**EPC STORMWATER REVIEW COMMENTS
 IN ORANGE BOXES WITH BLACK TEXT**

EL PASO COUNTY STORMWATER MANAGEMENT PLAN CHECKLIST

Revised: October 2021

**EC1**

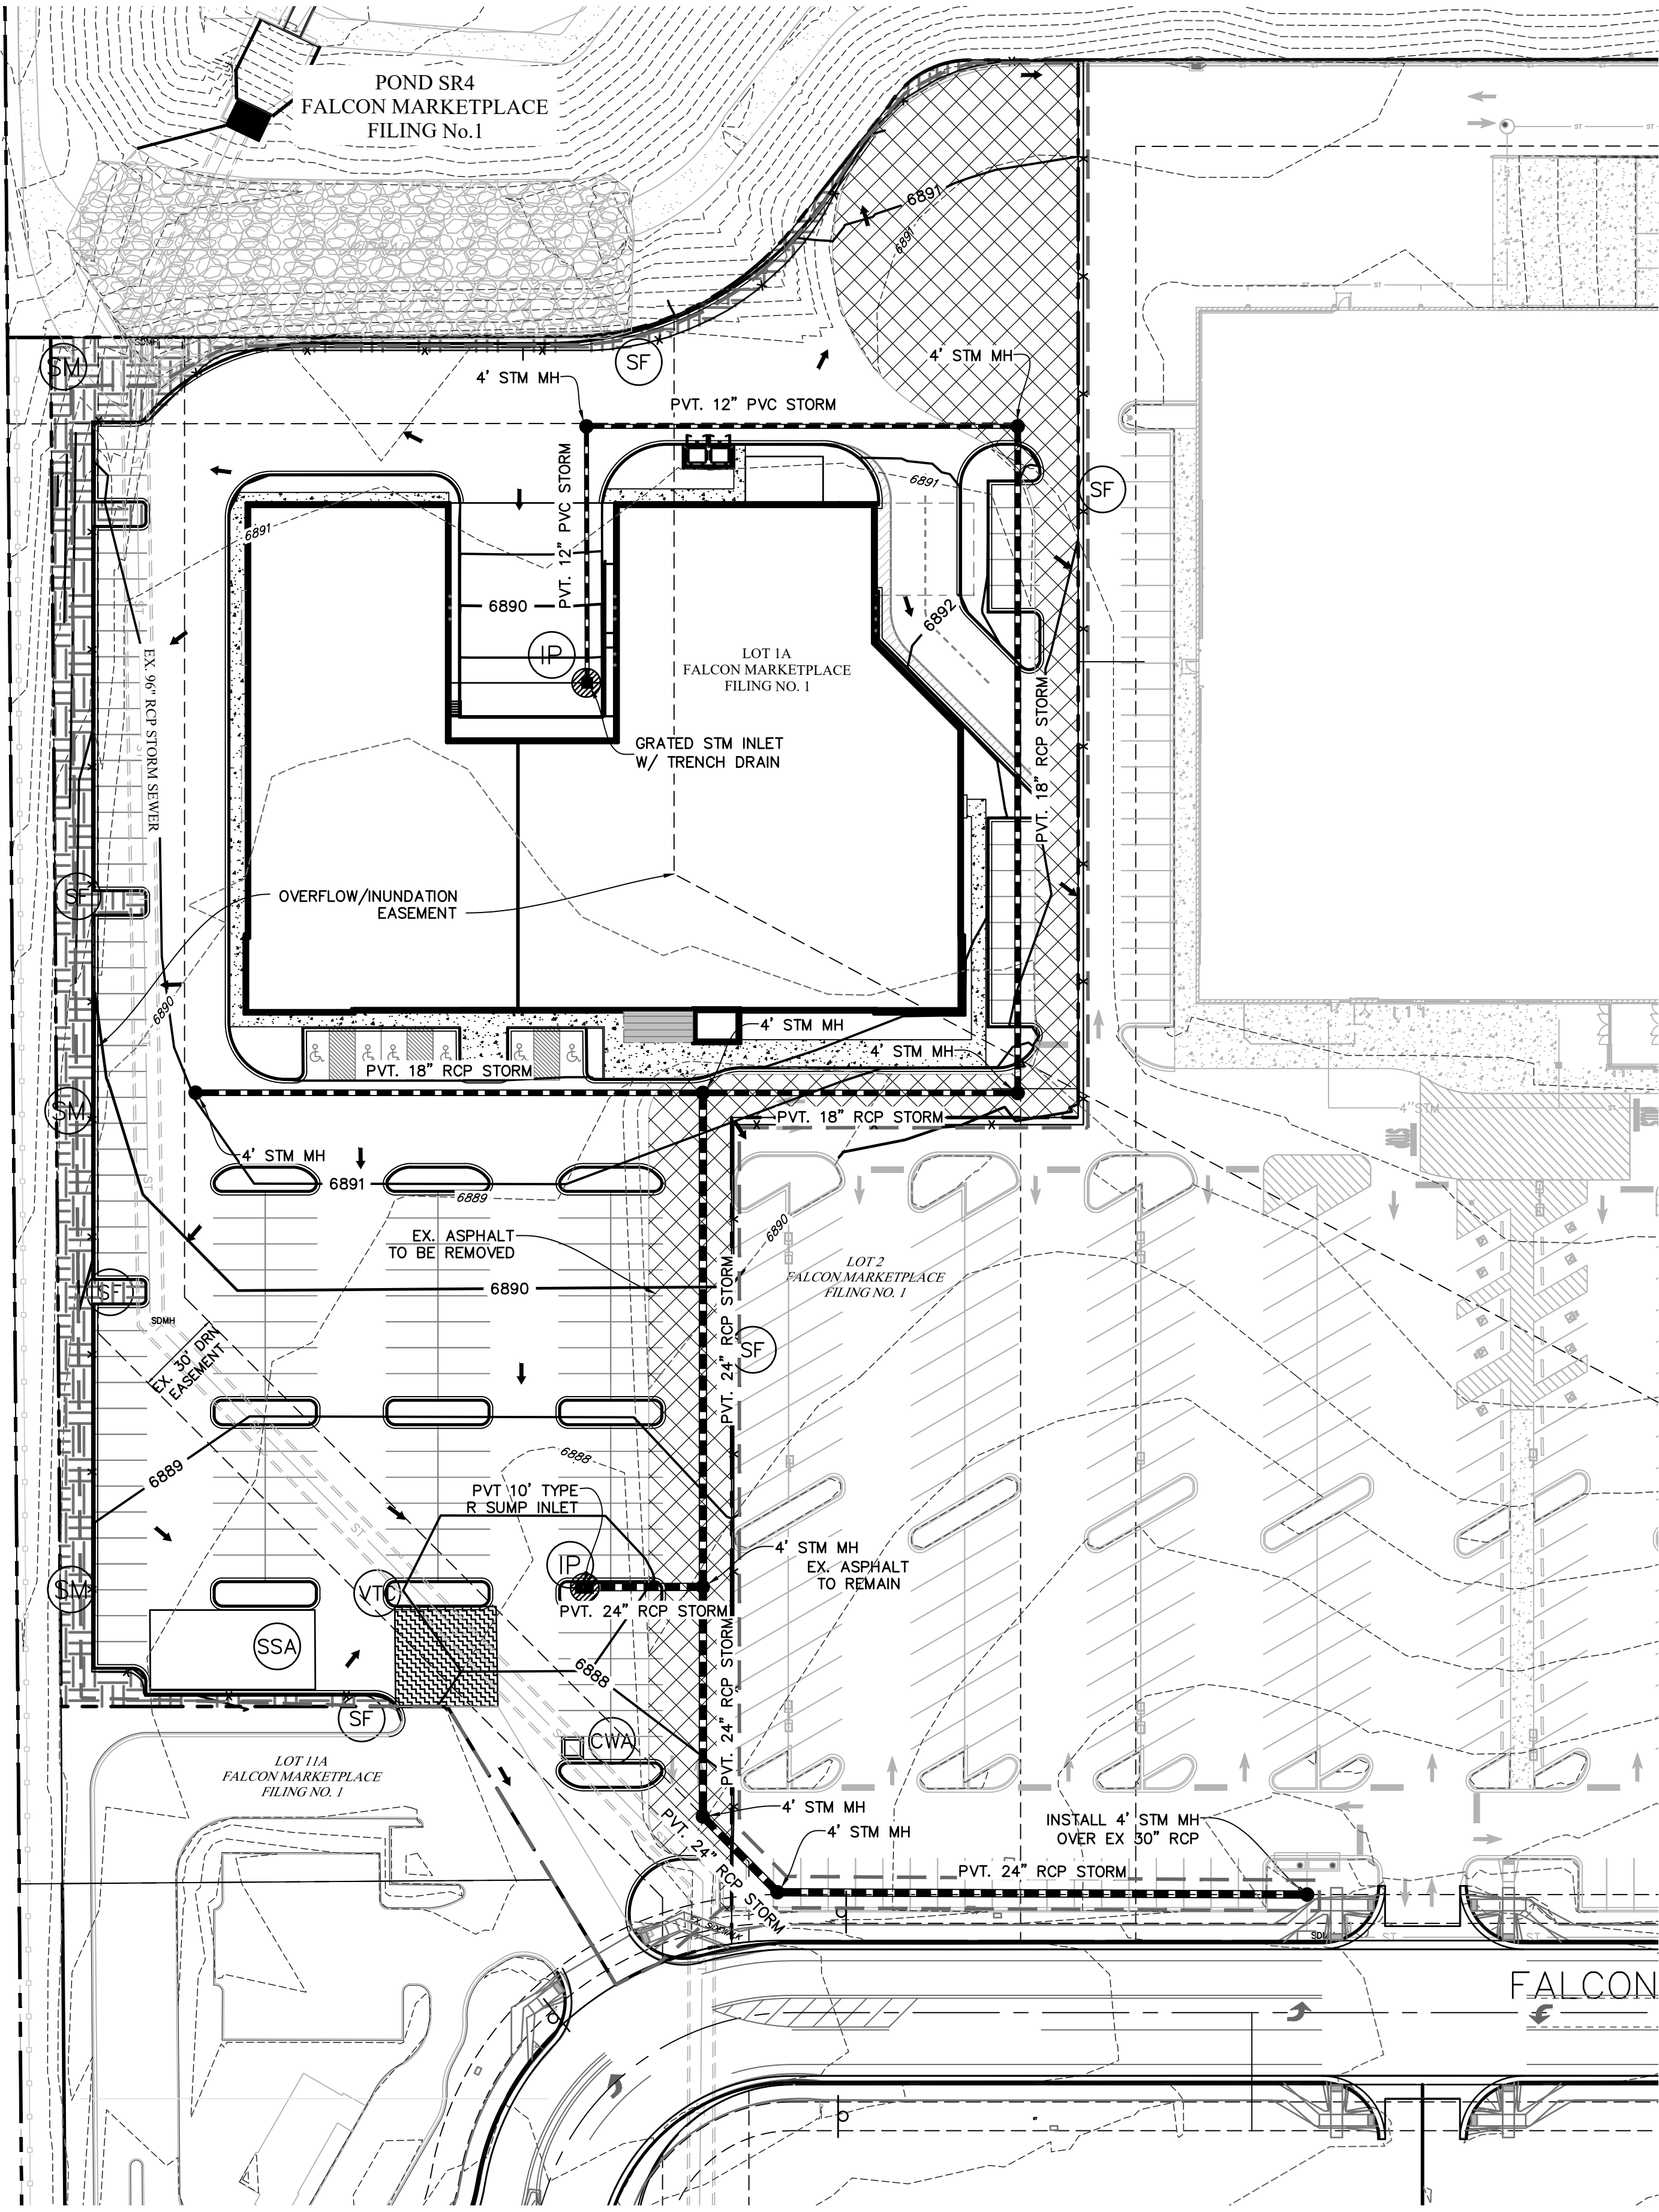
20	Technical drawing details for all control measure installation and maintenance; custom or other jurisdiction's details used must meet or exceed EPC standards		Y
21	Procedure describing how the SWMP is to be revised		Y
22	Description of Final Stabilization and Long-term Stormwater Quality (describe nonstructural and structural measures to control SW pollutants after construction operations have been completed, including detention, water quality control measure etc.)		Y
23	Specification that final vegetative cover density is to be 70% of pre-disturbed levels		Y
24	Outline of permit holder inspection procedures to install, maintain, and effectively operate control measures to manage erosion and sediment		Y
25	Record keeping procedures identified to include signature on inspection logs and location of SWMP records on-site		Y
26	If this project relies on control measures owned or operated by another entity, a documented agreement must be included in the SWMP that identifies location, installation and design specifications, and maintenance requirements and responsibility of the control measure(s)		N
